**KIRKLEES METROPOLITAN COUNCIL
INVESTMENT & REGENERATION SERVICE**

Reference No: 2021/62/90531/W

Site Address: 6, Hill Grove, Salendine Nook, Huddersfield, HD3 3TL

Description: Erection of single and two storey extensions

Proposed layouts and elevations.

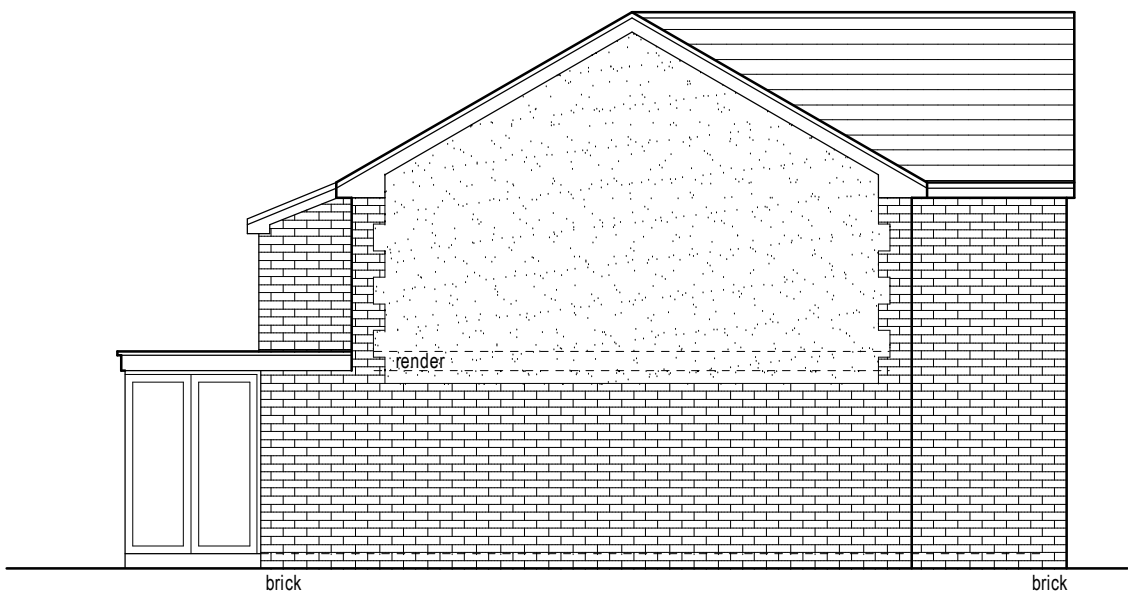
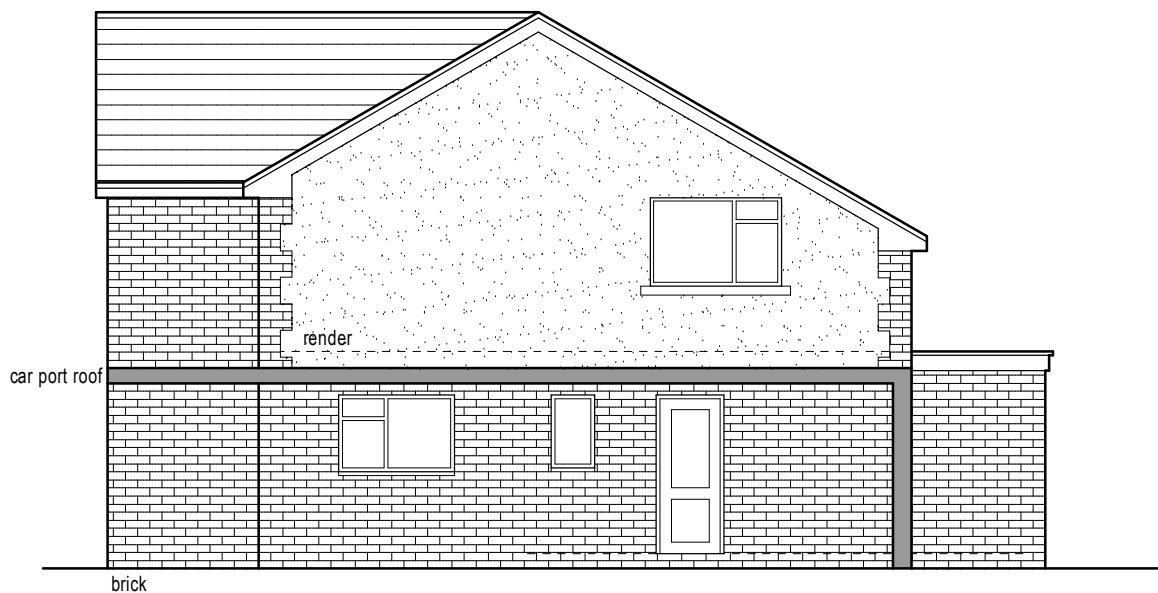
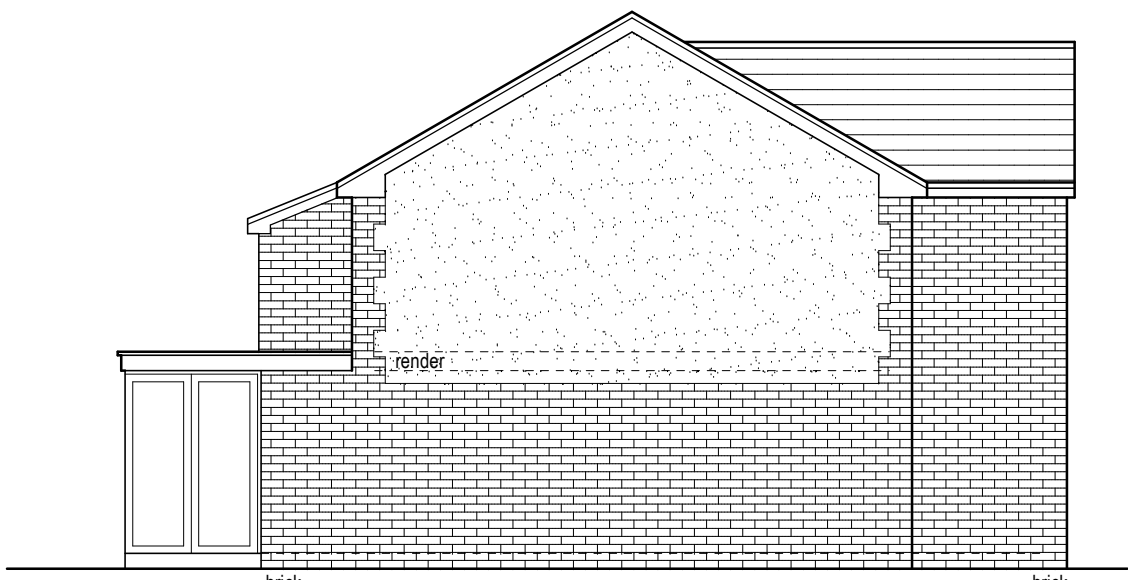
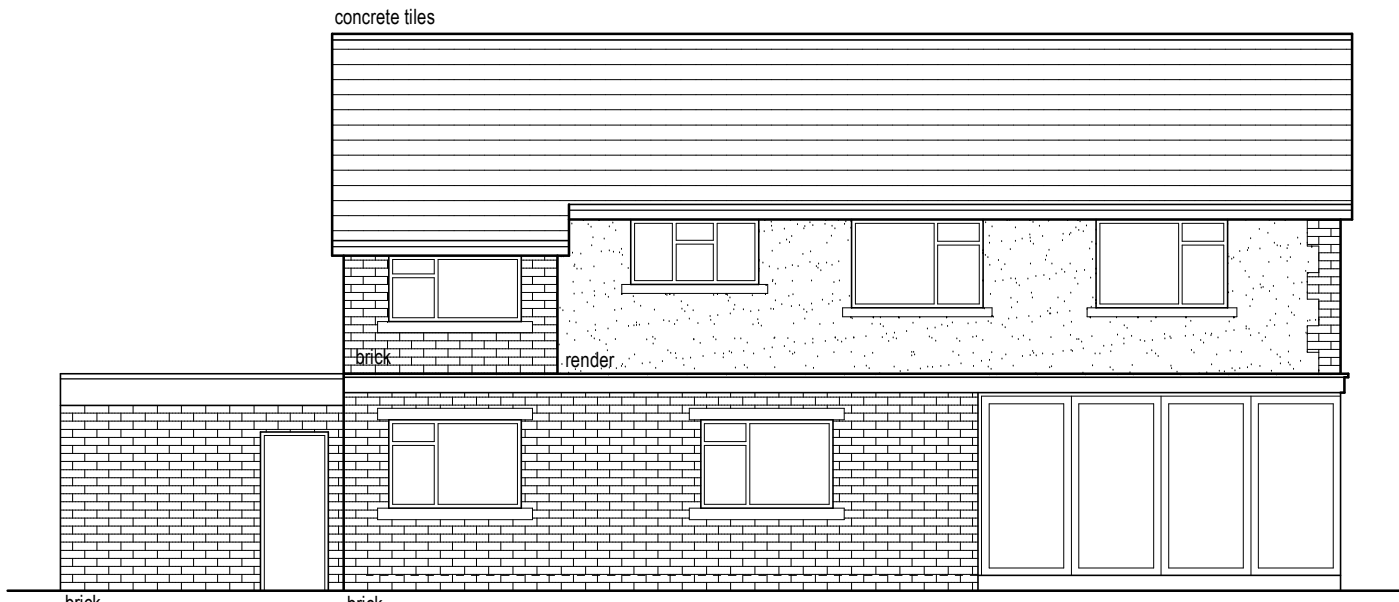
Amendments were sought to reduce the ridge height of the proposed gable extension to ensure that it appeared subservient to the host dwelling.

therefore would not appear as an alien feature in the streetscene. It was requested however that the ridge height of the gable extension be dropped down from the ridge of the host dwelling to ensure that it is subservient and to slightly reduce the overall scale and massing.
